PRE-HEARING STAFF ANALYSIS

Rezoning Petition No. 2008-73

Petitioner: Charlotte Mecklenburg Housing Partnership

Location: Approximately 64.5 acres on the west side of Statesville Road between Newland Road and Woodward Avenue

SP101

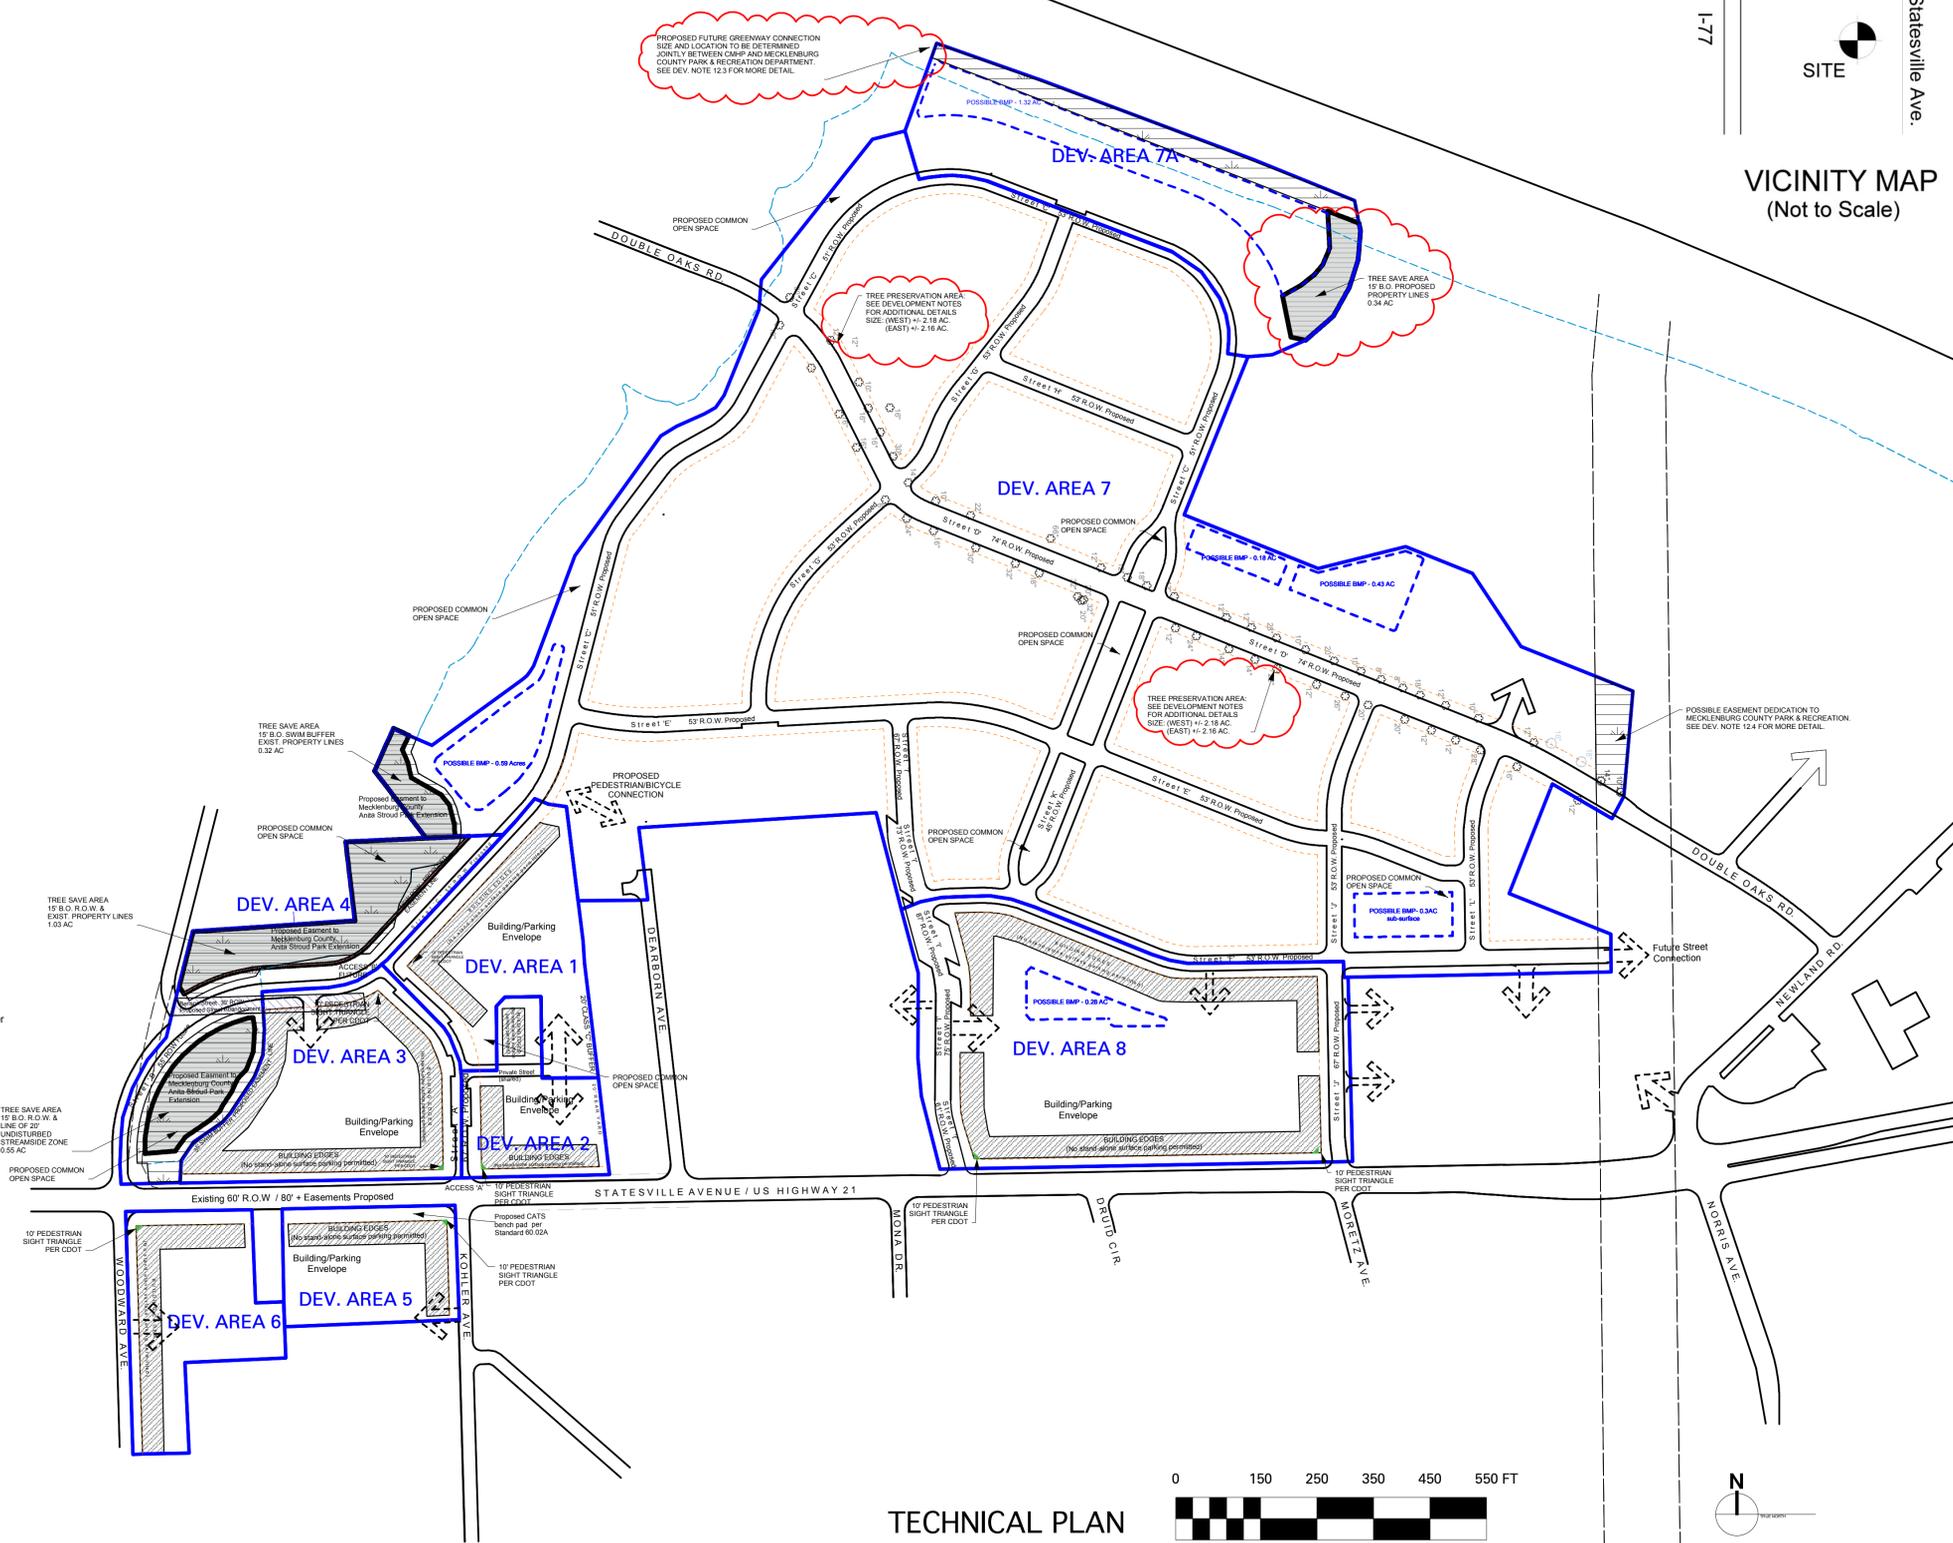
The note on sheet SP101 that refers to "best efforts" to save trees along Double Oaks Road needs to be modified. Either the alterations to Double Oaks Road need to be asymmetrical, allowing the trees on one side to remain undisturbed, or the note needs to commit to a tree preservation plan that will be undertaken and executed during the construction process and be approved by the City's Urban Forestry personnel.

Approximately 70% the proposed tree save areas consist of the trees along Double Oaks Road, where "best efforts" will be made to preserve the existing trees. These areas cannot be considered commitments to saving trees.

The "potential civic use" noted on sheet SP102 needs to be added to the permitted uses on sheet SP101 and sheet T101.
